Single Family Home

February 10, 2006

RE: Application for Single Family House, #295 Capisic Street

Upon review of the site plan, the City's Planning Division has the following comments:

C-100
 SHEET 1 OF 1

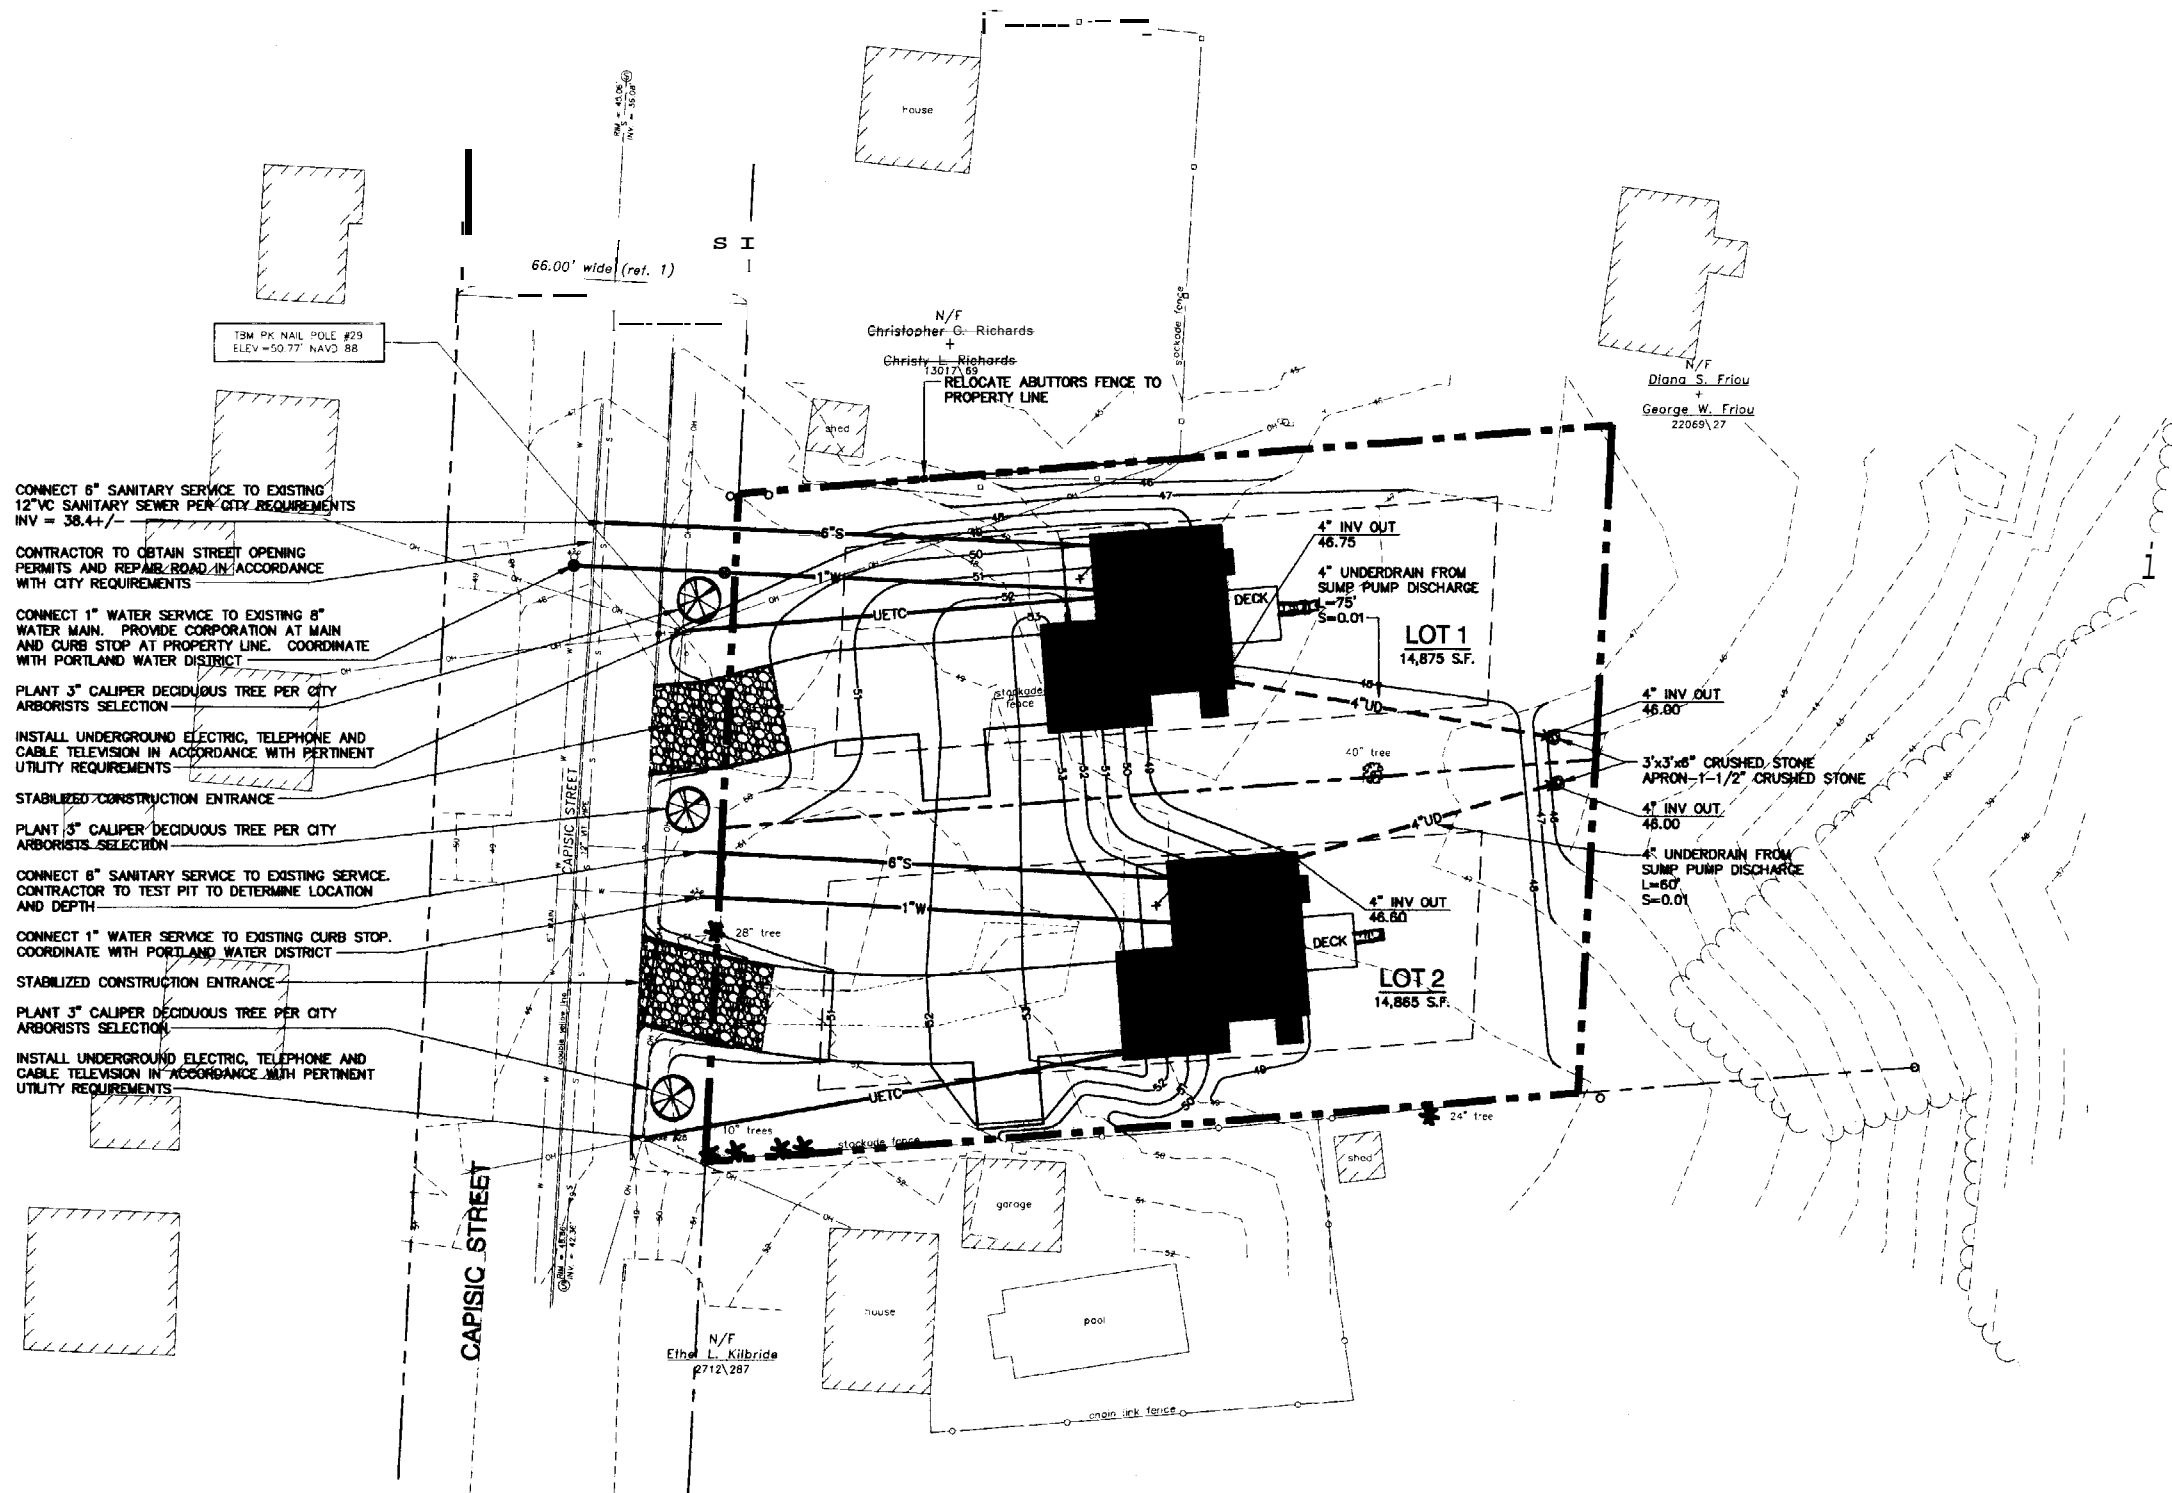
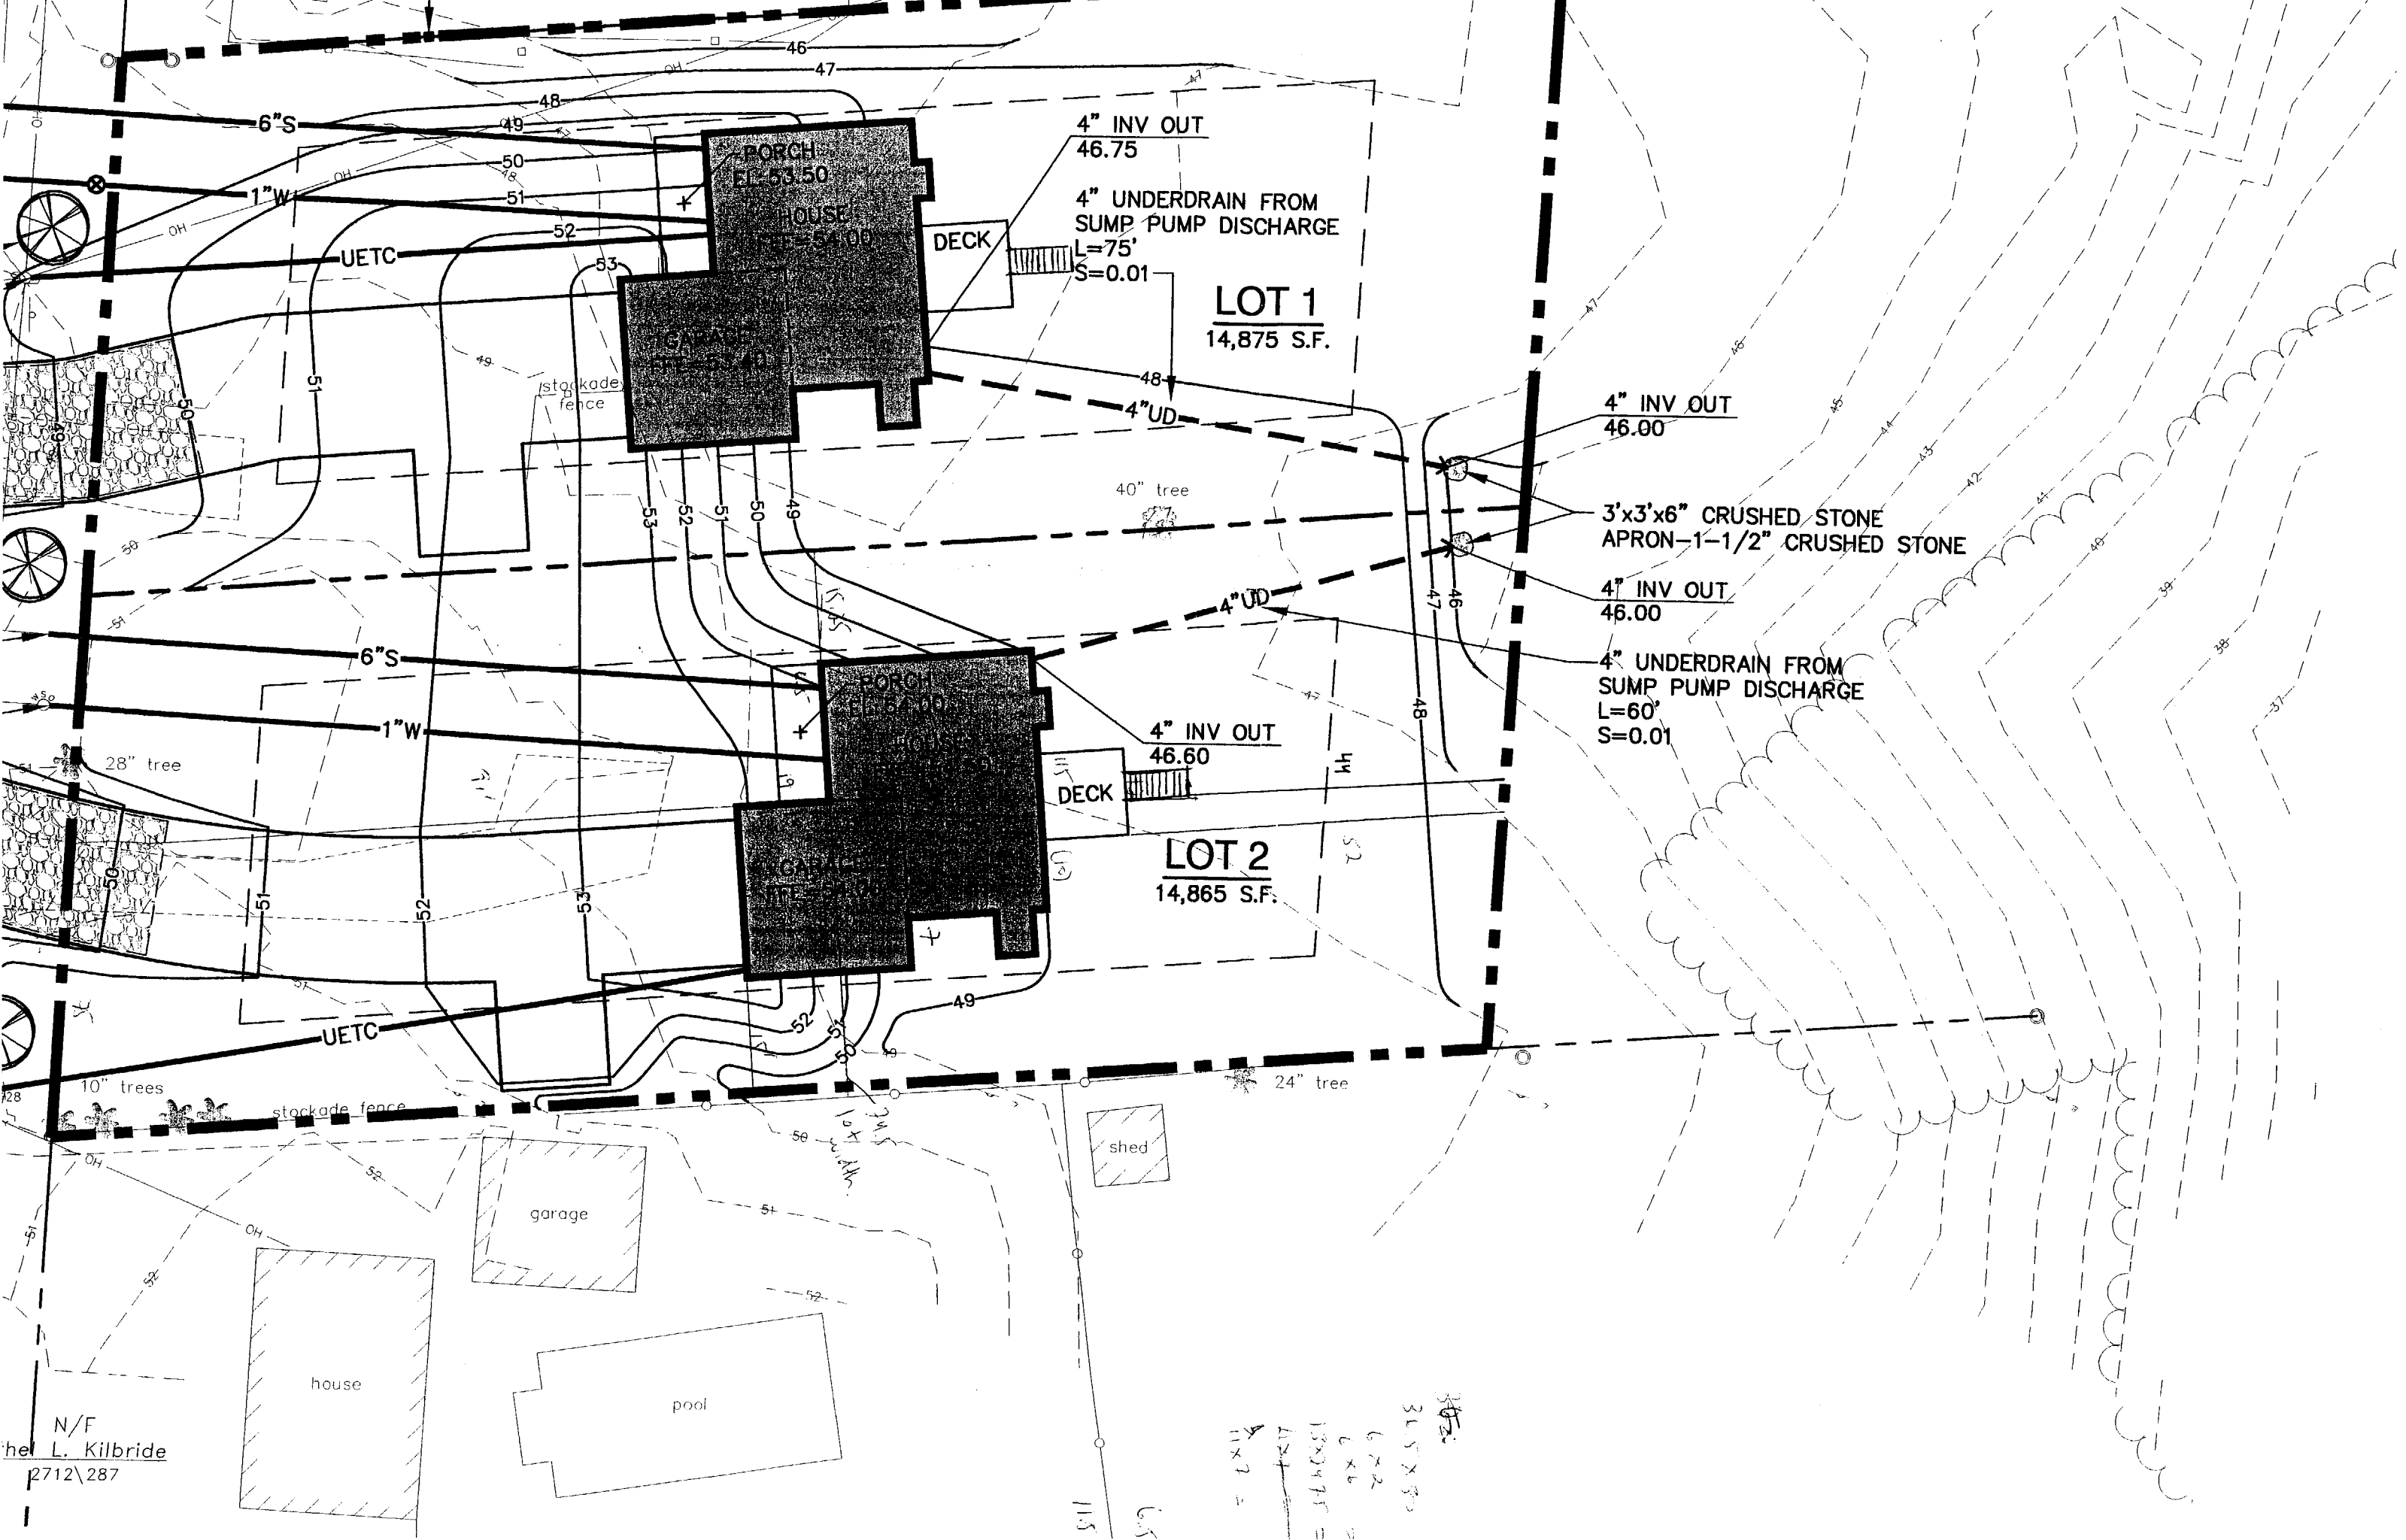
1. Please add silt fence/erosion control to the site plan so that it protects all areas of disturbance.
2. Please add a cleanout to the proposed sewer lead (required at 80' from sewer main).
3. Please modify the proposed topography along the side property lines so that drainage is directed towards the rear of the properties as opposed to aimed at the abutting/side properties. This will ensure that neighboring properties aren't negatively impacted with drainage.
